July 13, 2017

RE: Harnett County Land Use Existing Tank Application # 17-5-41703

The Harnett County Department of Public Health, Environmental Health Division evaluated the above referenced property at the site designated on the plat/site plan that accompanied your existing tank application. According to your application requesting, **a 24x24 Deck**, the evaluation was done in accordance with the laws and rules governing wastewater systems in North Carolina General Statute 18A.1950 including related statutes and Title 15A, Subchapter 18A, of the North Carolina Administrative Code, Rule.1950 and related rules.

SITE PLAN APPROVAL

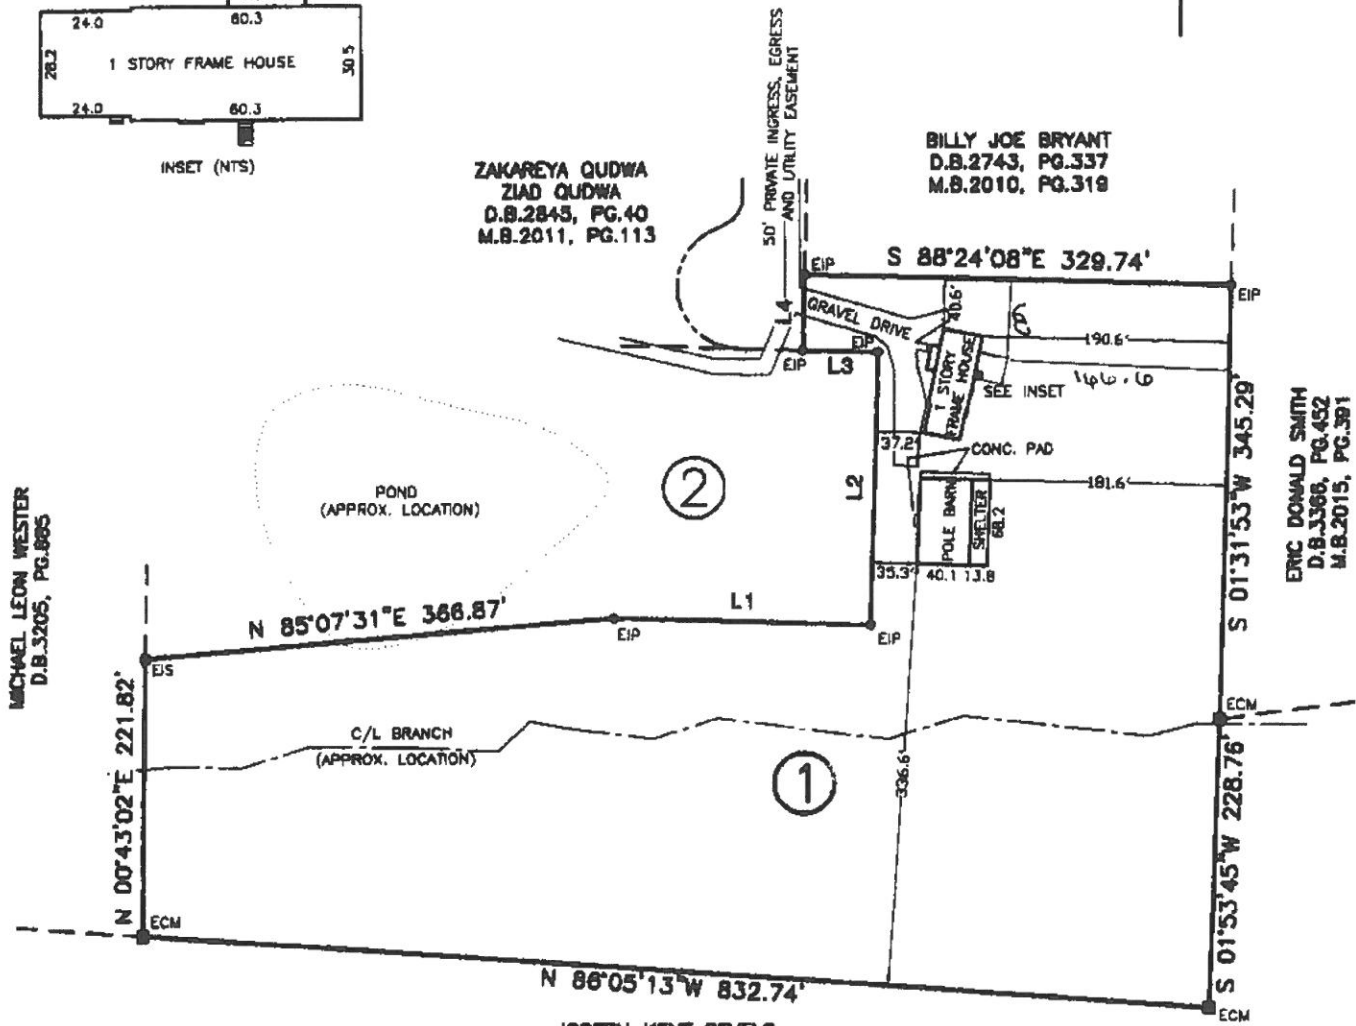
Based on the criteria set out in Title 15A, Subchapter 18A, of the North Carolina Administrative Code, Rules .1950, the evaluation indicated that the site is **UNSUITABLE** for the addition requested. Therefore, your request for an existing tank is **DENIED**. The site is denied based on the following:

- 15A NCAC 18A.1950a {16} - Any swimming pool must be 15' from any part of septic system.**
- 15A NCAC 18.1945{b} - Each lot shall have original septic system plus repair area. Based on the information provided by your Soil Consultant your current system is undersized and must be expanded to meet your current or proposed use. Please submit a proposal from you Soil Consultant showing both the proposed expansion and repair area.**
- 15A NCAC 18A.1950 {10} - Any building to be 5' from septic tank and/or from drain line. Drain Lines appear to run under proposed deck locations.**
- 15A NCAC 18A.1950{c} - Nitrification fields and repair areas shall not be located under paved areas or areas subject to vehicular traffic.**

You will need to revise you application at Central Permitting to reflect these changes.
